From: Amanda Scholes on behalf of Planning.Responses
Sent: 09 January 2020 09:20
To: Planning Scanning
Subject: FW: BR/286/19/PL - 1-2 The Parade Bognor Regis - WITHDRAWAL

project title	
1-2 Argyle Road, Bognor Regis	
drawing title	
Proposed 1st and 2nd Floor Plan

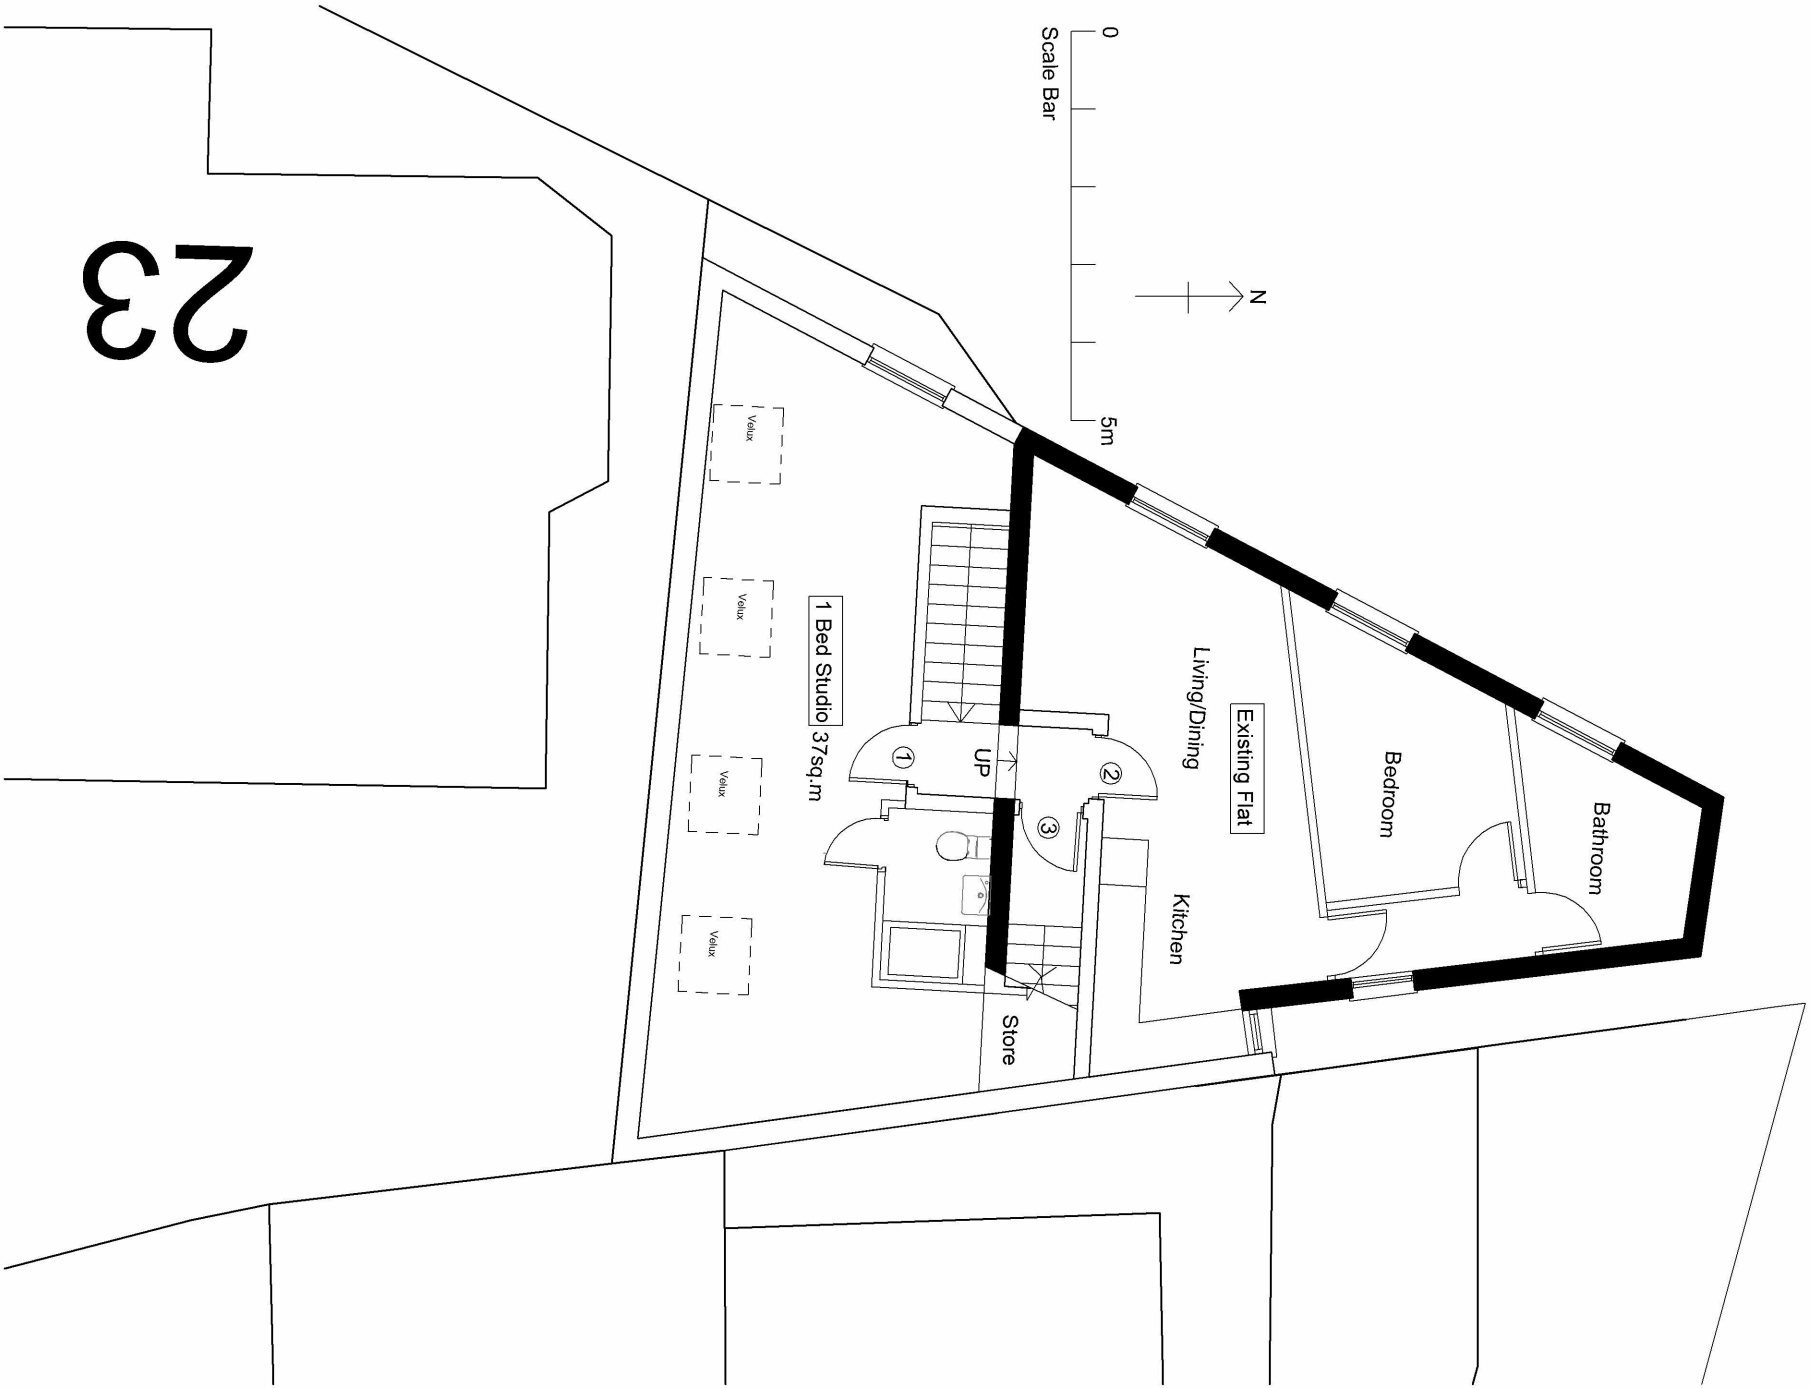
- Enclosing and loss of light impact of additional storey on amenity of neighbouring gardens to the east and north
- Enclosing impact of side extension on 1st floor bedroom window to no.23
- Internal floor areas – both new studio units appear to comply with national standards for minimum GIA of 37sqm

project title	1-2 Argyle Road, Bognor Regis		
drawing title	Proposed Elevations

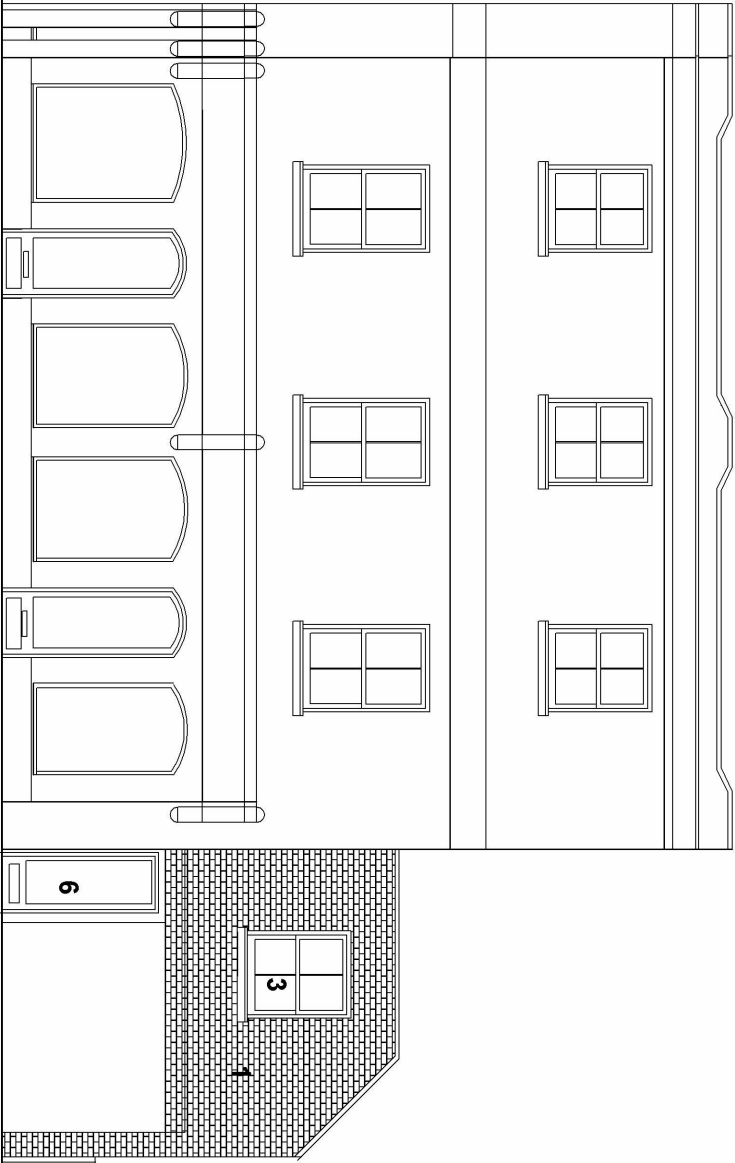
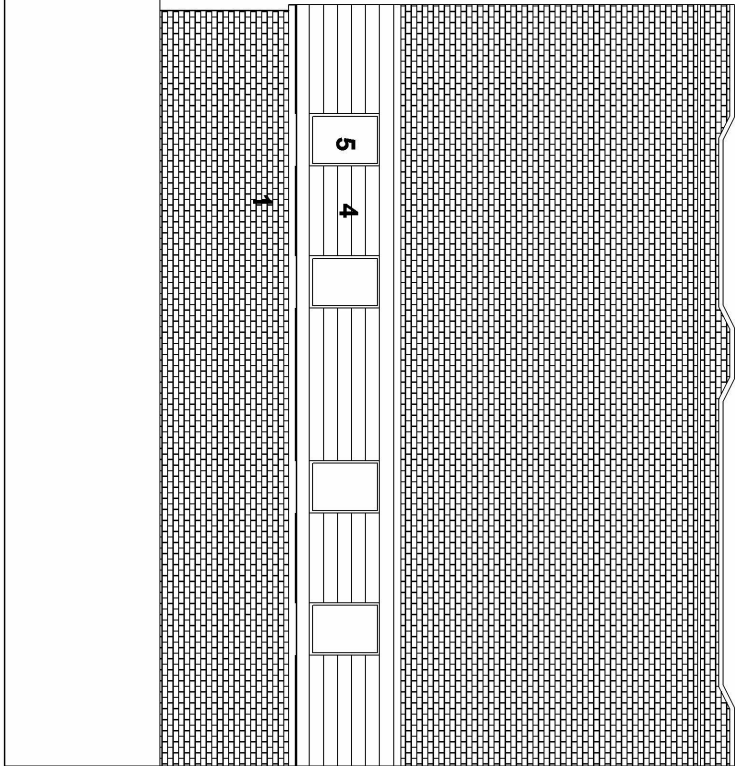
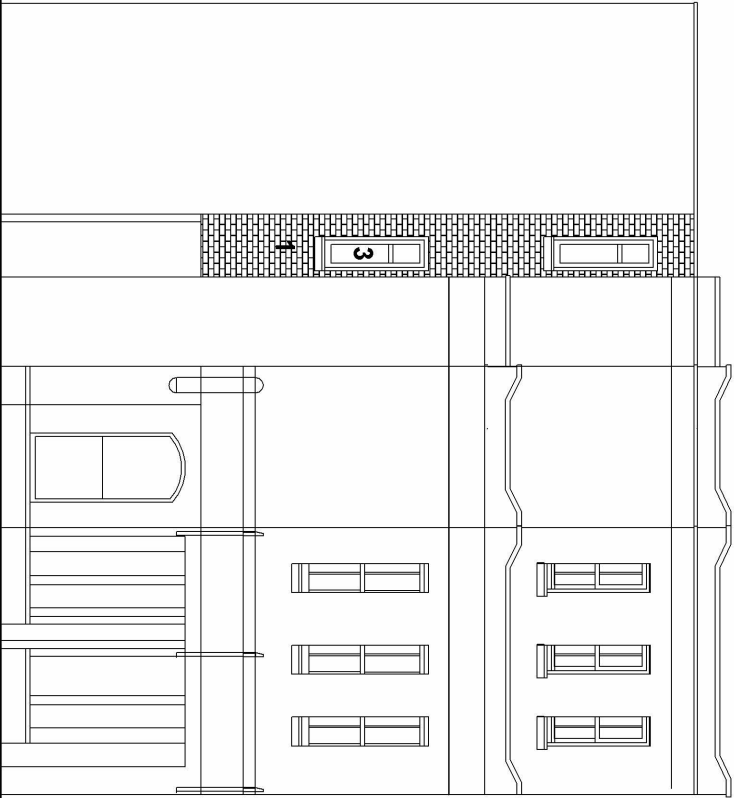
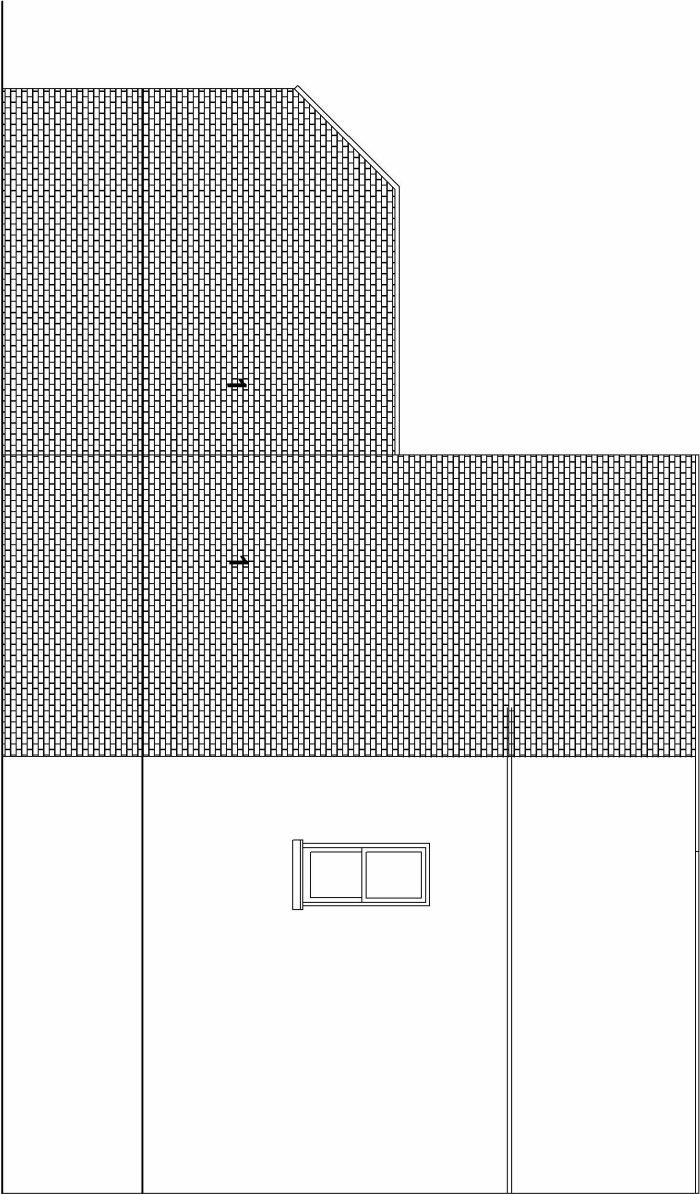
- Proposed additional storey would result in the building dominating the immediate streetscene near this visually prominent corner location
Whilst it is acknowledged that there is a 3 storey block (Argyll Court) opposite the site (the terrace behind on Steyne St is not 3 storey but 2 storey with roof accommodation), on this side and section of the street the gradient steps down from 3 to 2 storeys, so an additional storey making the building 3 storey would appear out of character with the mainly 2 storey form of buildings surrounding the site

- Reduced height of side extension and sloping roof would make it appear more subordinate in relation to the host building and reduce its impact on the gap between buildings – however, it would still erode the characteristic gaps between buildings

- The proposed design of the side extension with under-croft parking and stock brick rather than render to match the existing building would fail to appear sympathetic to the character of the building
